Consultation Response from: KC Environmental Health (Pollution & Noise Control)
2021/91792 - Lower Sowood Farm, Healey Lane, Brierfield, Dewsbury, WF12 0NT
Erection of extension and alterations to outbuilding to create dwelling forming annex accommodation associated with Lower Sowood Farm, Healey Lane, Brierfield, Dewsbury, WF12 0NT
Date Responded:
29th July 2021

Responding Officer:
Natalie Heaney

Responding Ref:
WK/202116446

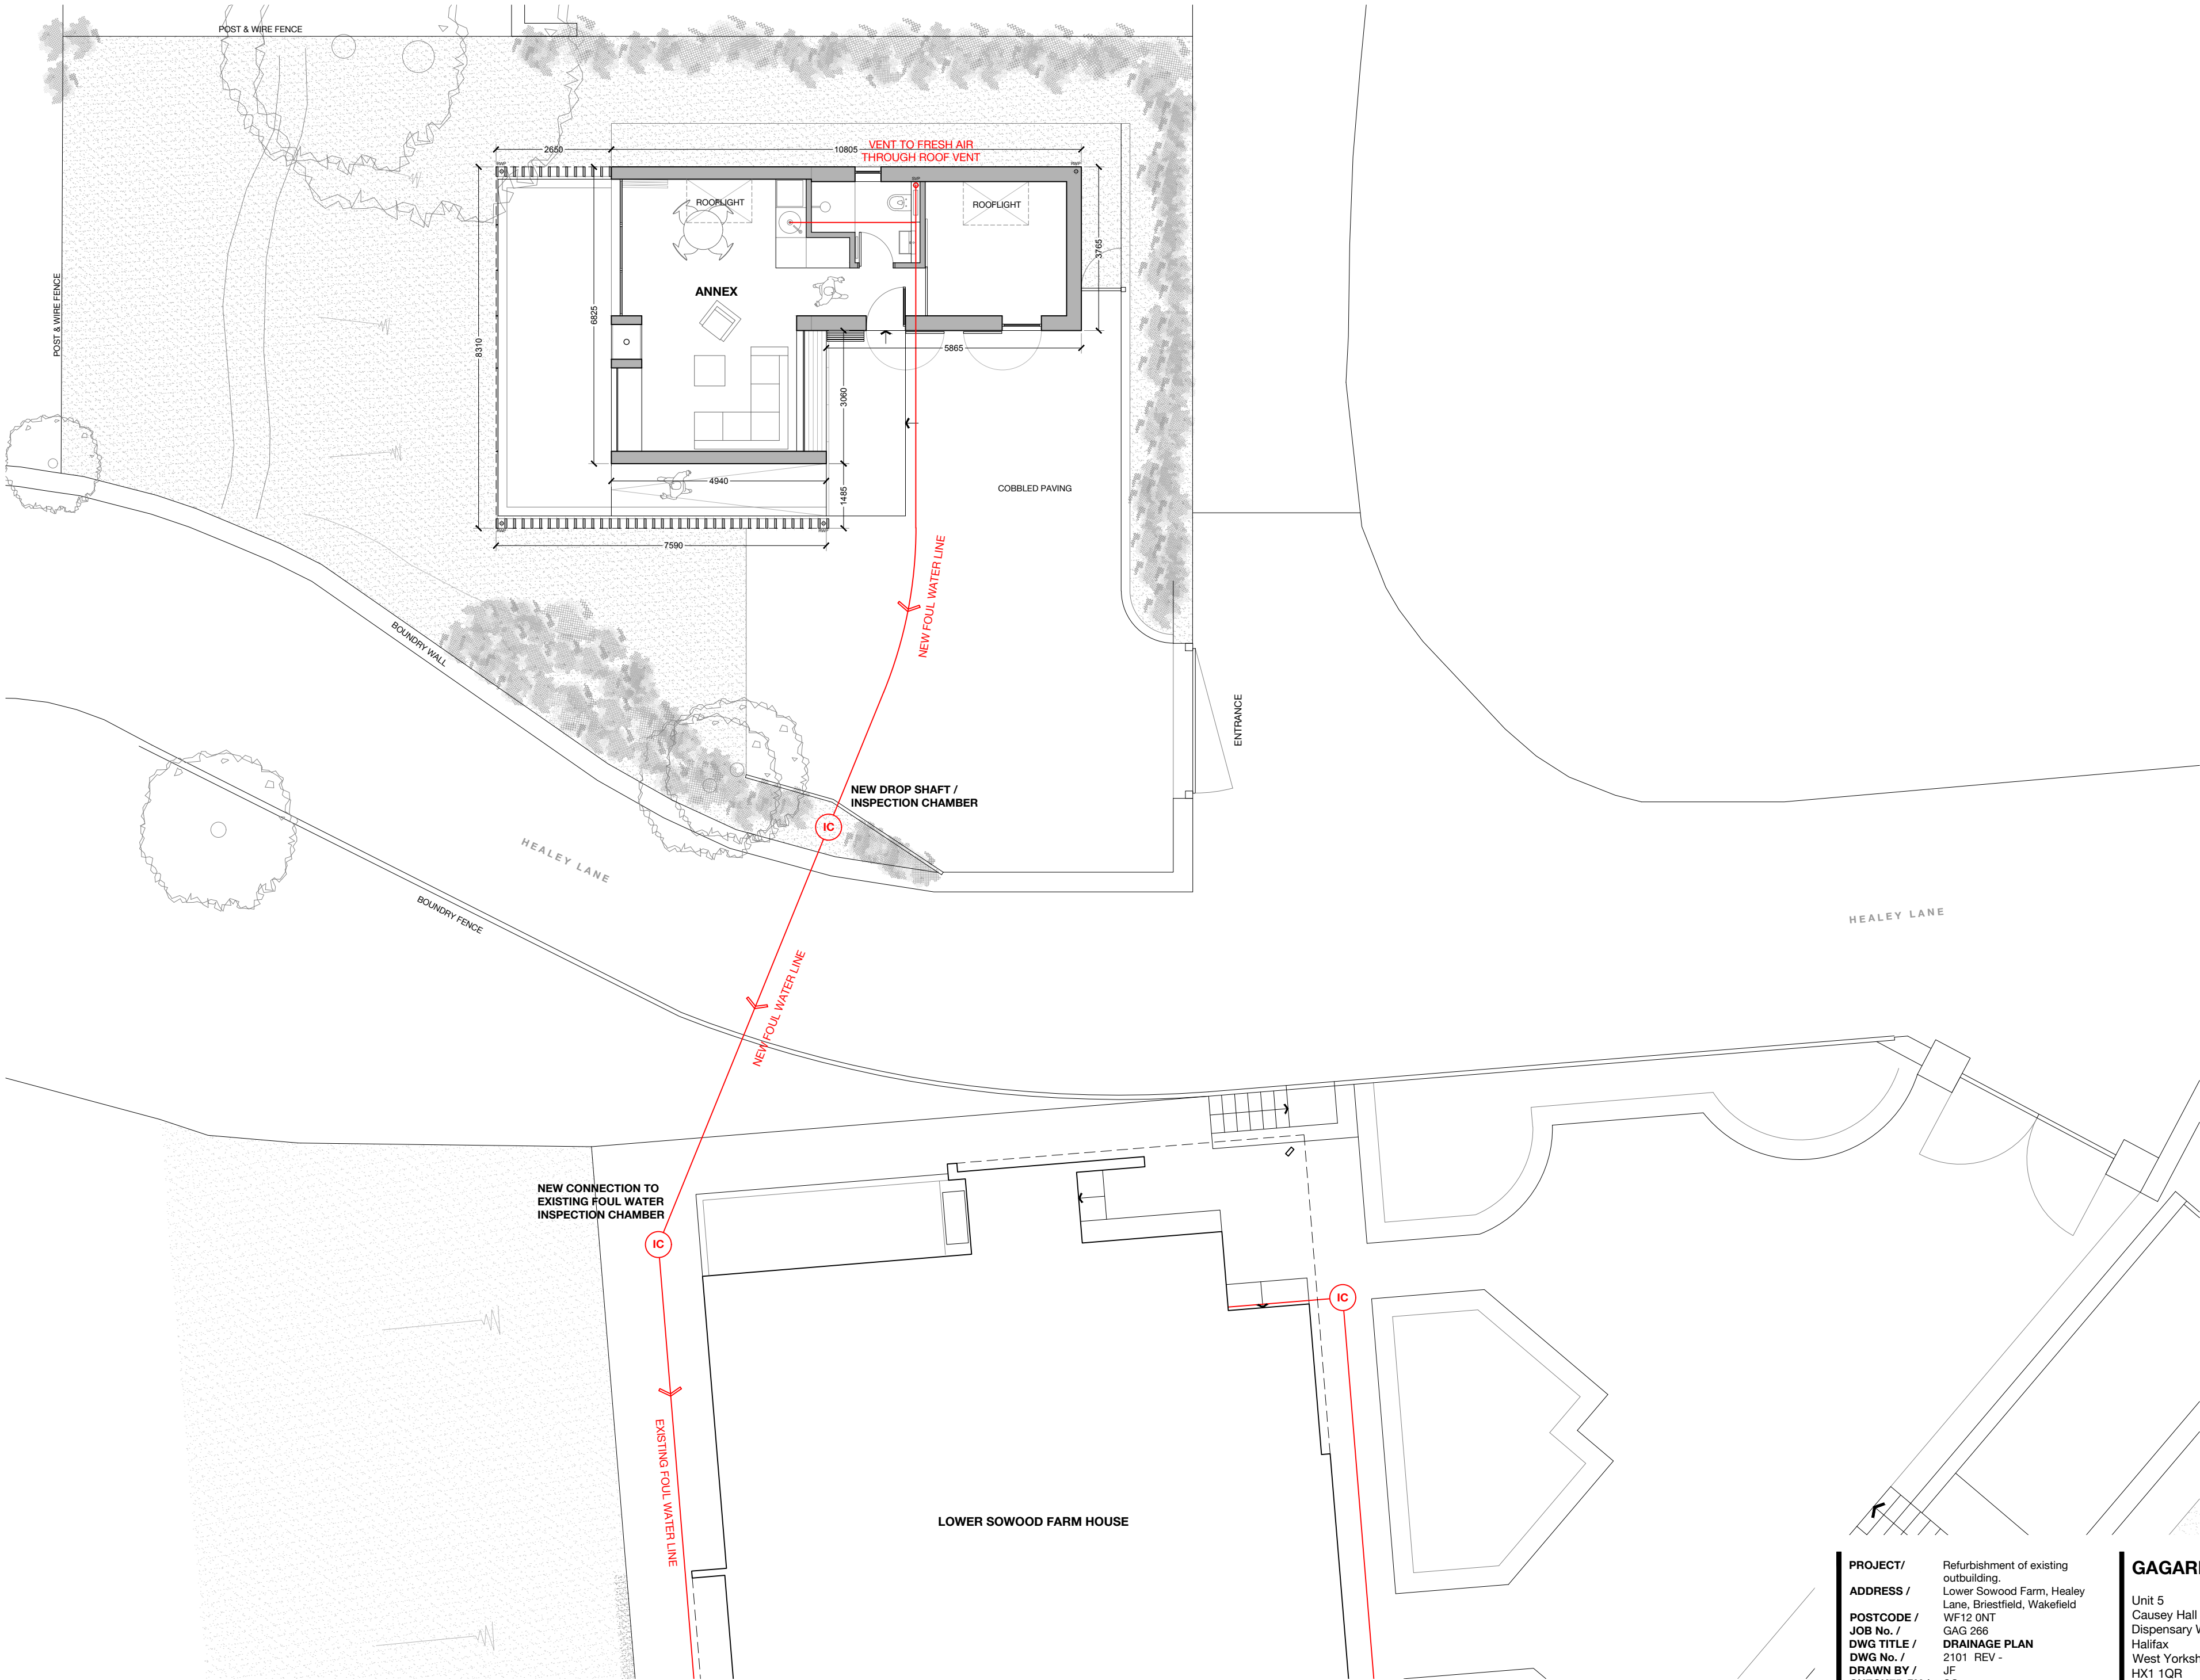
In the application forms provided with the application, it is proposed that a package treatment plant will be used to dispose of found sewage. However, no details have been included that identify the particulars of the foul drainage system proposed such as the dimensions and a plan that identifies the location of the drainage system in relation to the proposed development. These must be presented in support of the application and until adequate provision for foul drainage has been demonstrated, the application should not be determined.

It is understood that a mains drainage system is not available for the development. No detailed information has been provided regarding the proposals for providing an adequate system of foul water drainage which will be required by the building regulations. To ensure that it is feasible for the building regulations to be met and also avoid the possible need for a further planning application relating to the construction of a septic tank it is recommended that before determining the application the applicant provides detailed information to show how a

satisfactory foul drainage system is to be provided for the proposed development. The submitted information needs to demonstrate that the requirements of The Building Regulations 2010 Approved Document H, Drainage and Waste Disposal can be met and if a small sewage treatment plant (i.e. septic tank or package treatment plant) is proposed that the “General binding rules for small sewage discharges” can also be met. The details must therefore include the following information:

- a) The location of the tank (which must not be so near to any inhabited building as to be liable to become a danger to health or a source of nuisance (a minimum of 7m is required but over 20m and down slope is preferable) or in an area where there is a risk of flooding).

- b) The discharge details for the tank (which must not present any risk of contamination to any watercourse, underground water or drinking water supply).

- c) Details showing how adequate means of vehicular access will be provided to allow the tank to be periodically emptied and maintained.
- d) Calculations demonstrating that the tank will be of adequate capacity for the highest number of persons that may use the tank.

- e) If an existing tank is to be used, details of its condition / state of repair demonstrating that it is operating correctly and is impermeable to liquids

- f) Details of the necessary porosity and percolation tests carried out to establish the suitability of land that is to be used for any soakaway/land drainage of effluent.
